From: Amanda Scholes on behalf of Planning.Responses
Sent: 16 November 2020 20:04
To: Planning Scanning
Subject: FW: A/166/20/DOC - Manor Nursery, High Street, Angmering

Please upload onto Ocella the email below which is a consultation response from **ADC Drainage Engineers** to discharge of condition application **A/166/20/DOC** relating to Angels Nursery, Angmering.

We do not recommend discharge of these conditions at this time.

TITLE Proposed Site Surface Water Network Area Plan	
SCALE 1:500 @ A3	DRG. No. 60

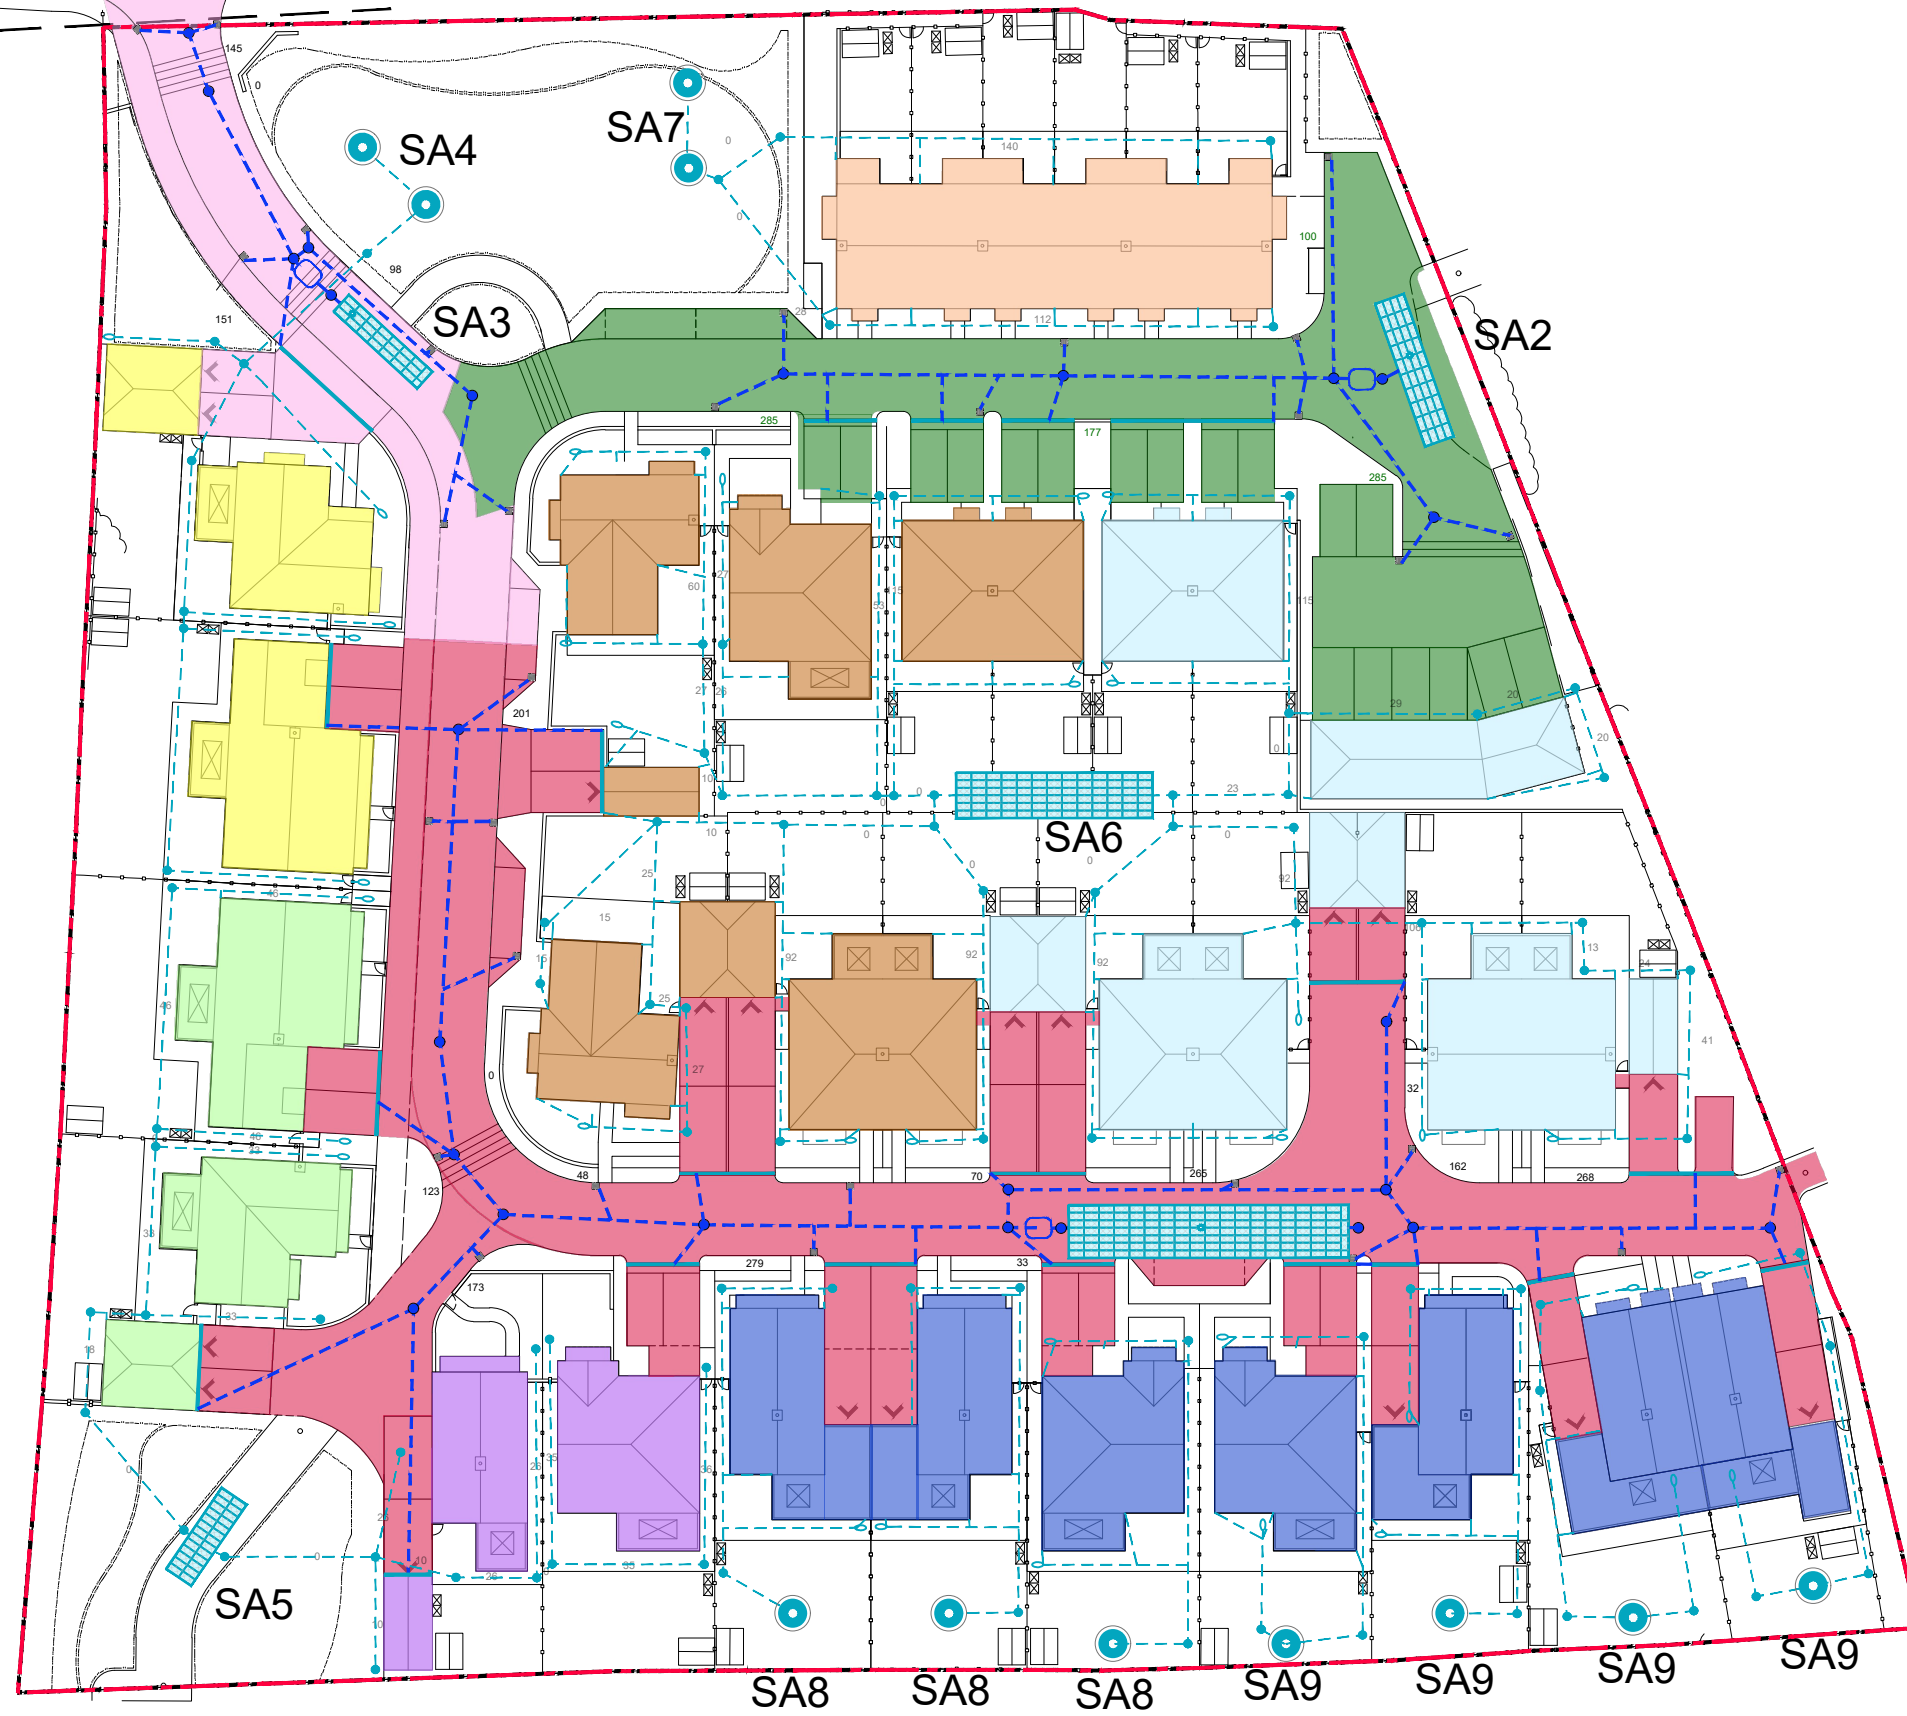
1. The impermeable areas plan supplied does not clearly show the areas draining to each soakaway. E.g. the areas draining to soakaways 8 and 9 are poorly defined. Please can the applicant supply a better impermeable areas plan which clearly shows the areas draining to each soakaway and which areas have had 10% urban creep allowance applied.

CLIENT	Roffey Homes Ltd		
PROJECT	Manor Nurseries Site Angmering		
TITLE	Proposed Drainage Strategy		
DRAWN	DATE	PROJECT NO.	
T Zajac	Mar 2018	22995	
ENGINEER	CHECKED	DWG. NO.	REV.
S Magowan		102	D
SCALE	1:250 @ A1

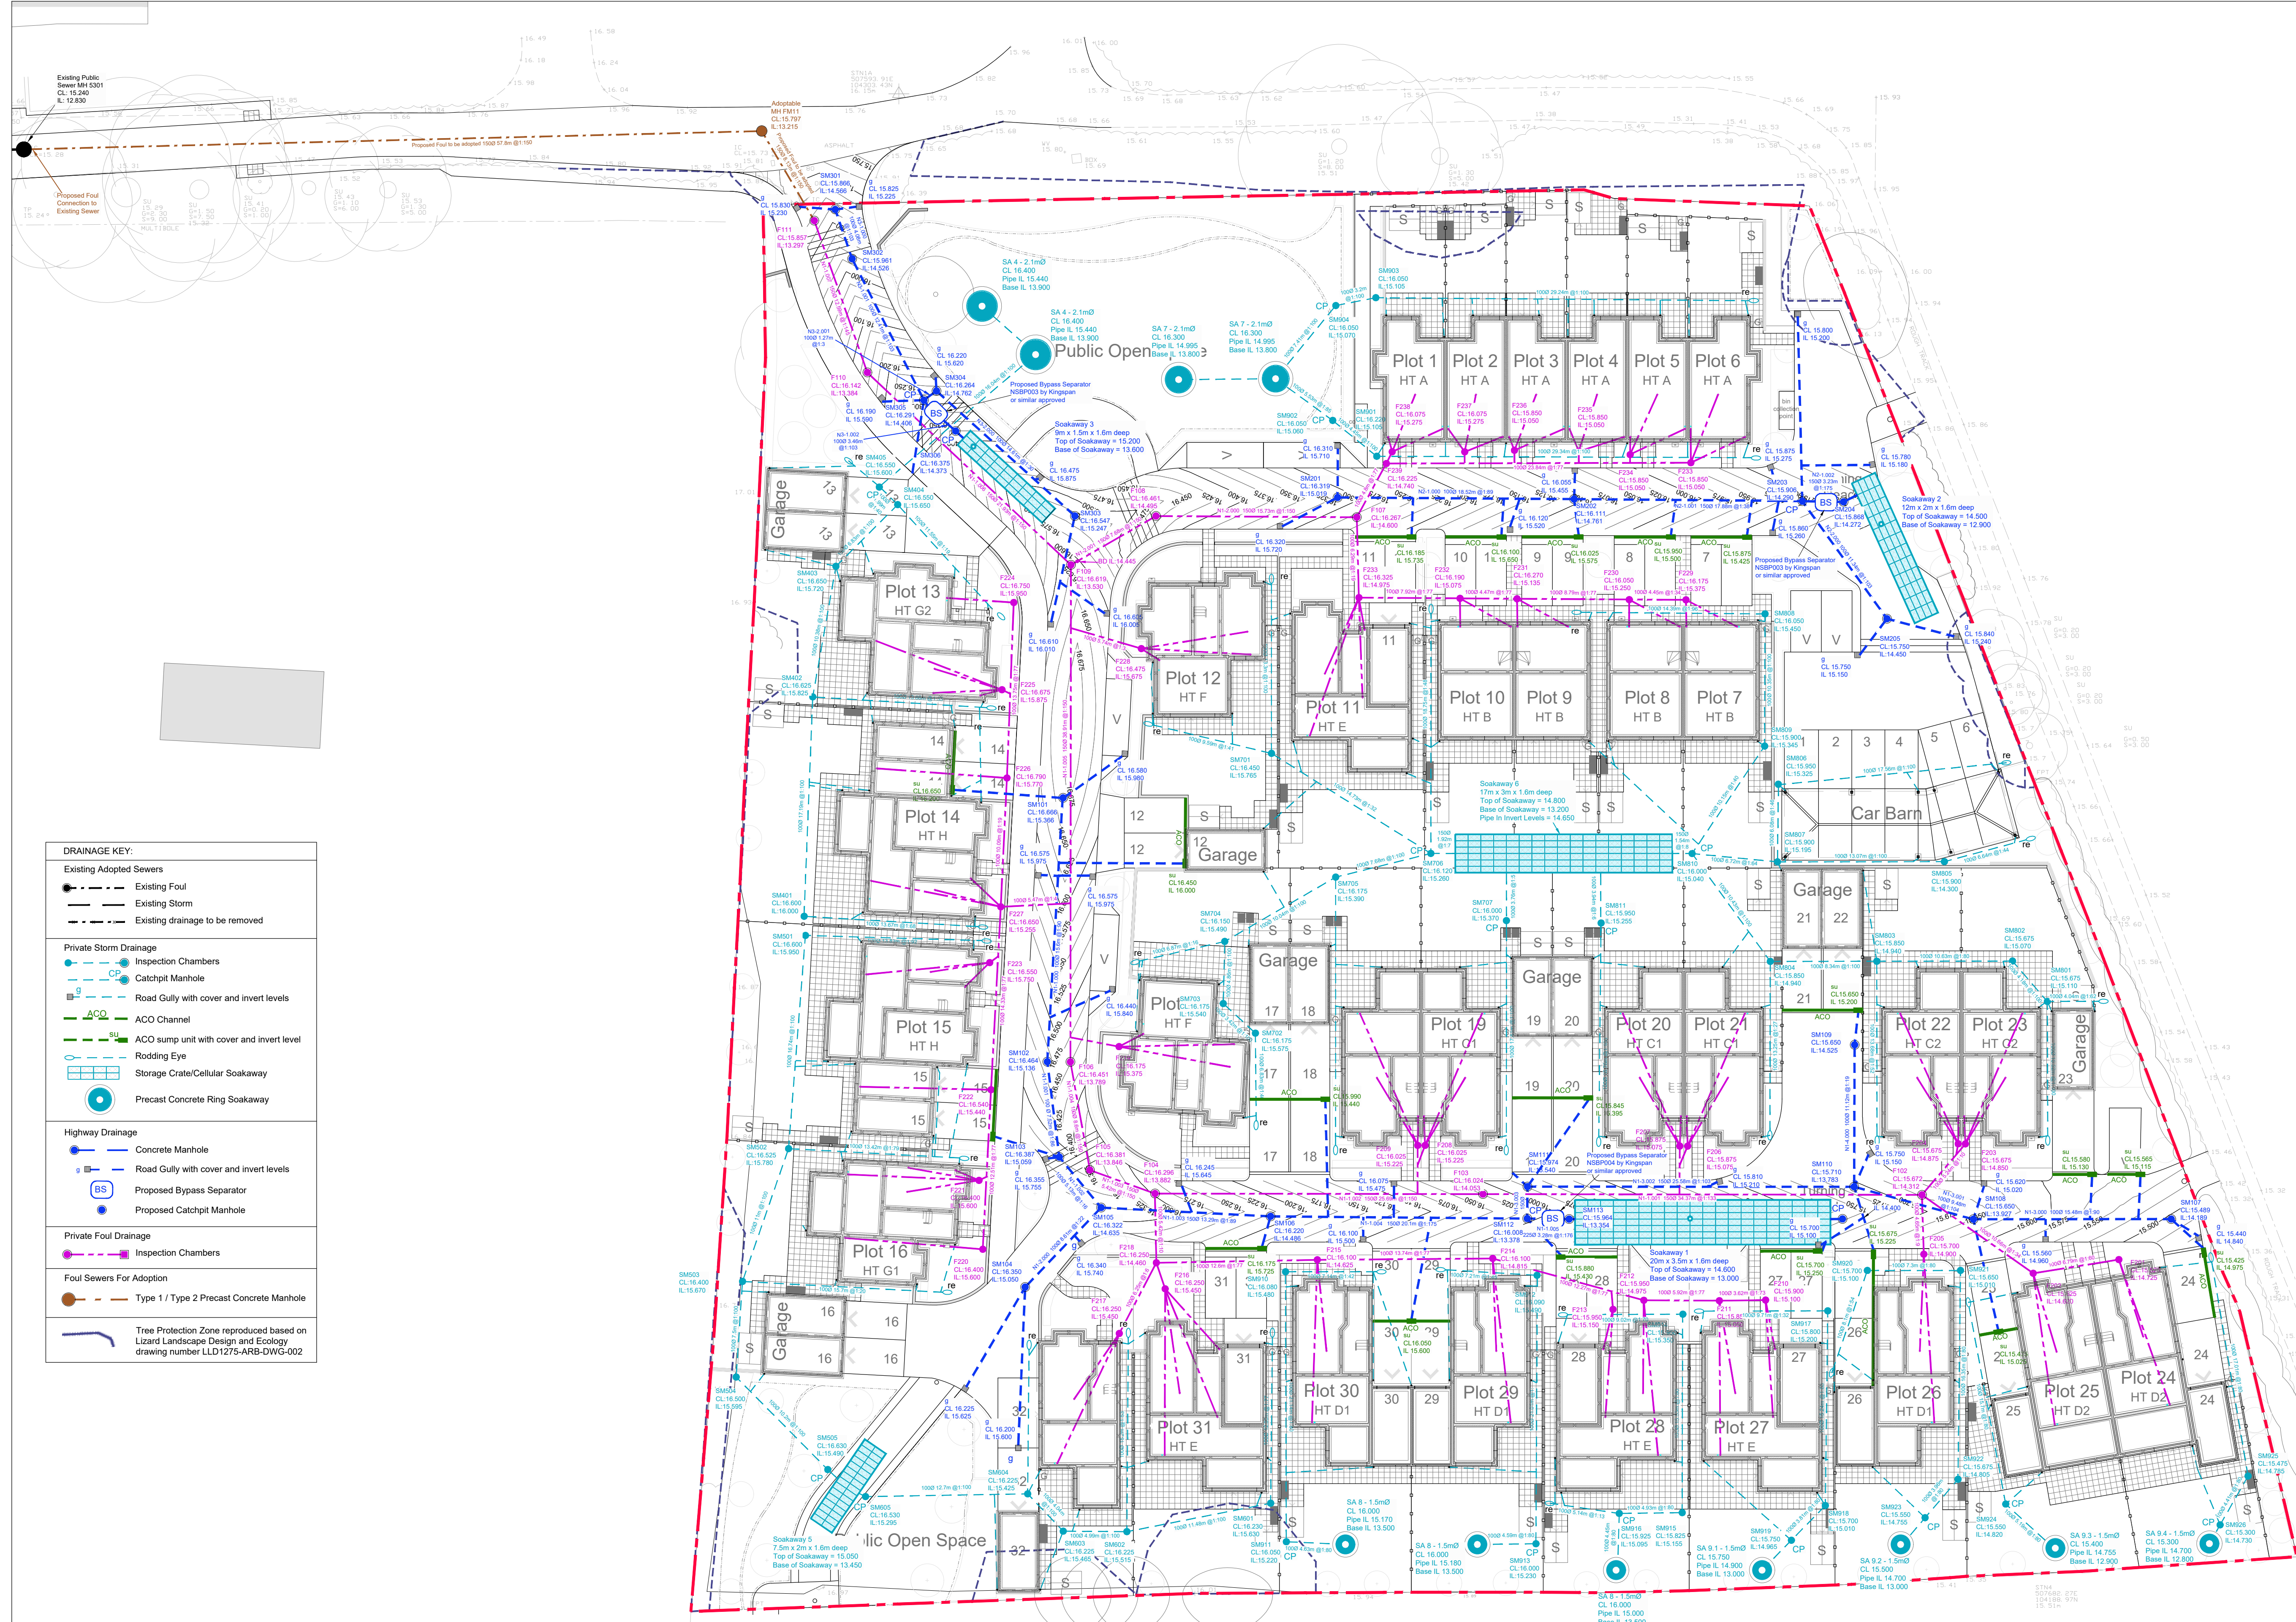
2. Please detail invert and cover levels of gullies and ACO drains.
3. Some pipes appear to terminate without connections. For example where are the pipes upstream of N1 2.000 connecting to/from?

4. Please provide details of the proposed bypass separators and how these will meet the requirements for hazard mitigation indices.
5. It is unclear how the pipes that are supposed to be able to pass above soakaway 1 will in reality do this. They are draining surface features, i.e. ACO and gullies, and are meant to pass above the top of the crate which is at 14.6mAOD and then within 1m connect into a pipe that has an upstream invert level of 13.943. Please detail how this is supposed to work especially given some of these connections are not via manholes.

6. All pipes must achieve 1m/s velocity at full bore.
7. SA4 has a maximum water level of 16.575, this is greater than the cover level stated on the drawings. The calculation details for SA 4 are different to those on plan. Please correct so that they are consistent.

8. The calculation details for SA 7, SA8, and SA9 are different to those on plan. Please correct so that they are consistent.
9. Construction detail drawings need to be provided, as per our checklist.
